# ENG-PUDSP20005-R2-MDDP-redlines.pdf Markup Summary

. Master Development Drainage Plan – Bent Grass  
Residential Subdivision, by Galloway &  
Company, May 2019.

Sheet 6-10 Falcon DBPS Conceptual Plan West Tributary El Paso County, CO

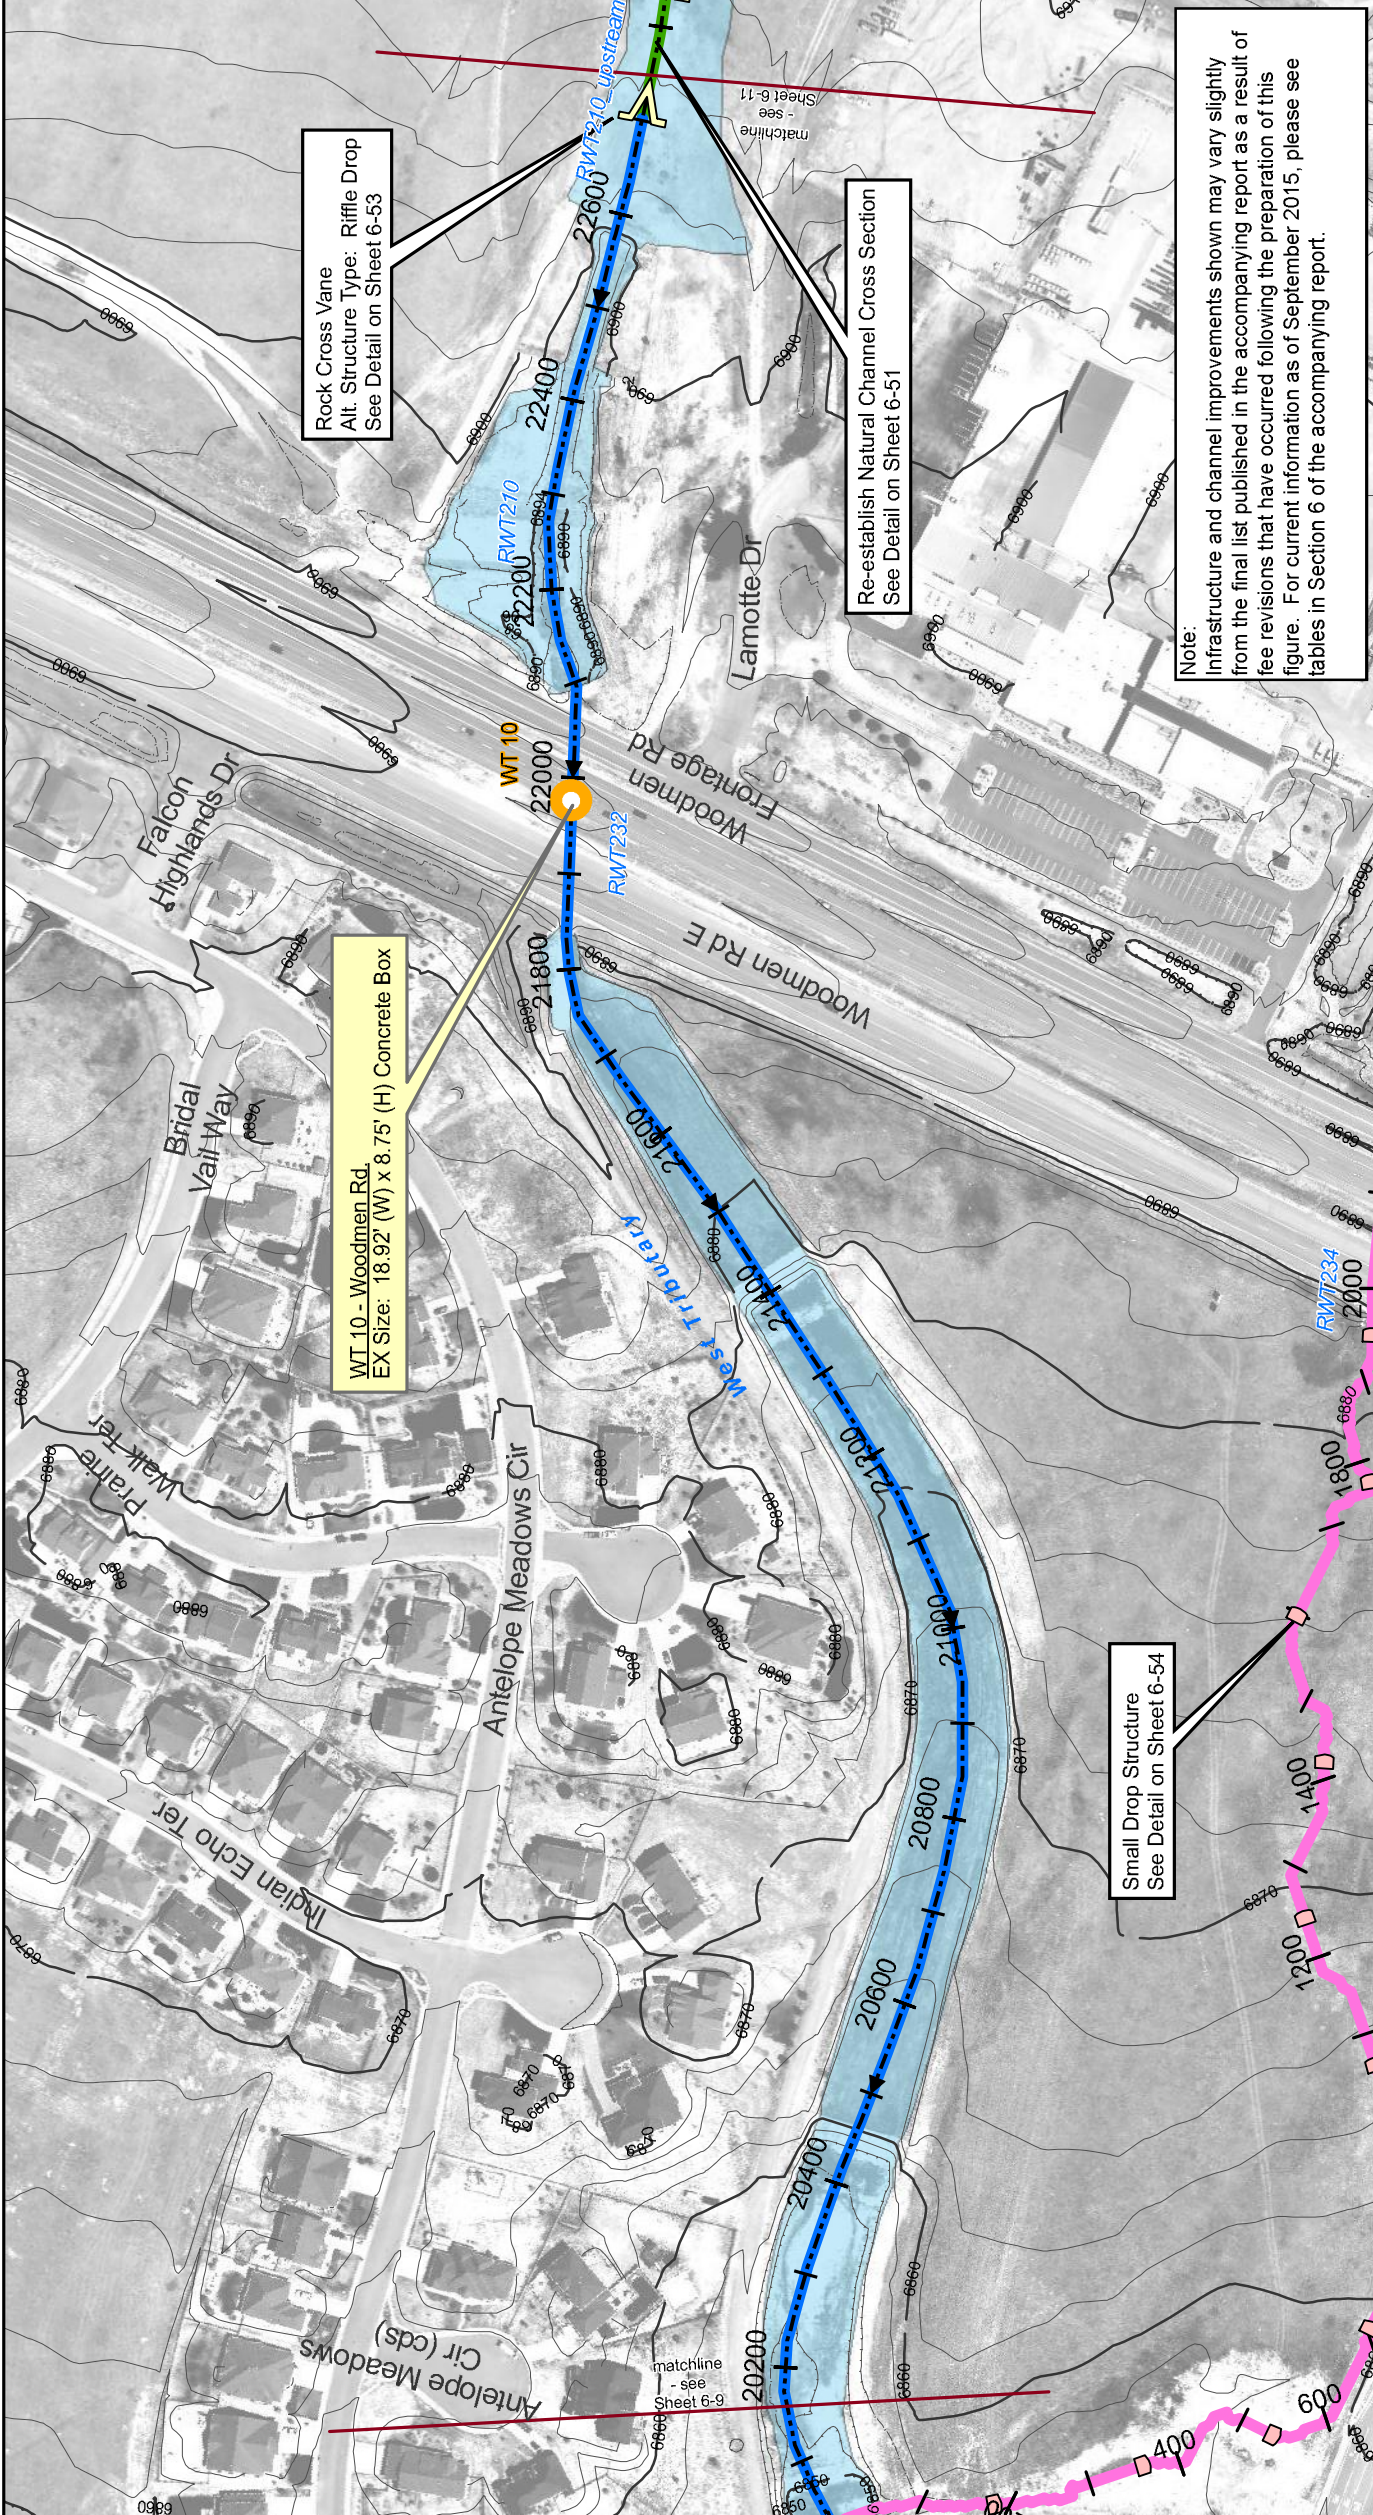
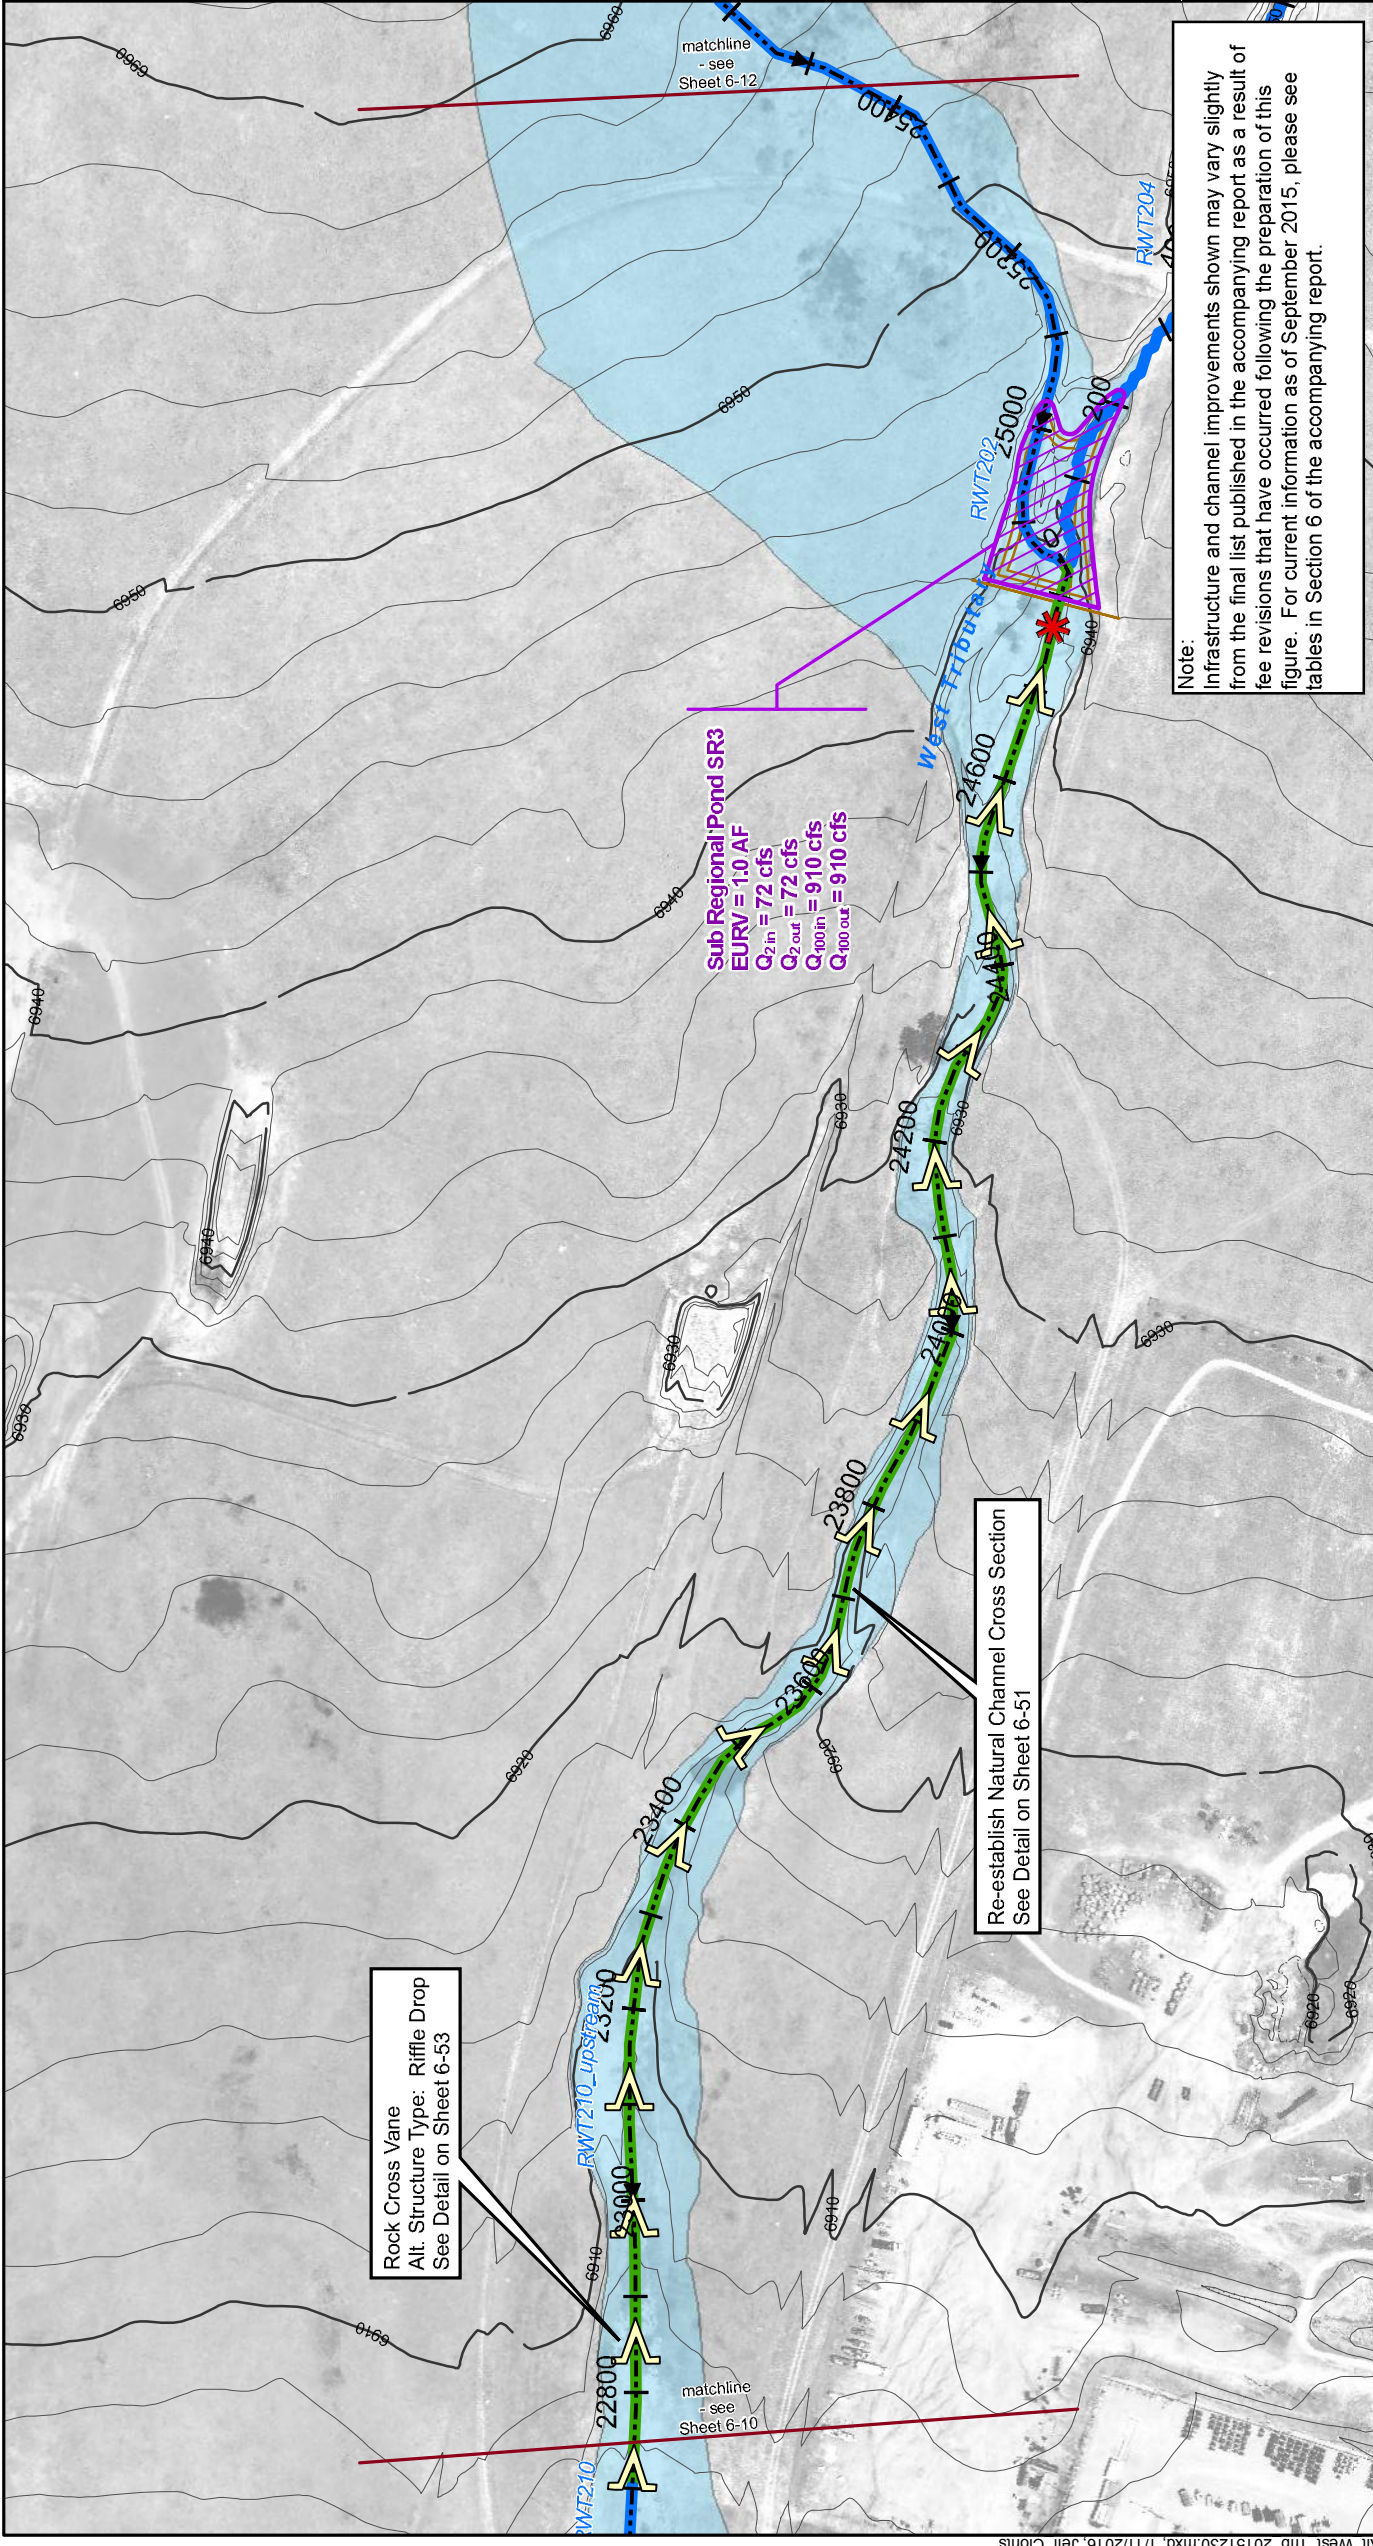
Provide conceptual channel plan and DBPS details for RWT 210
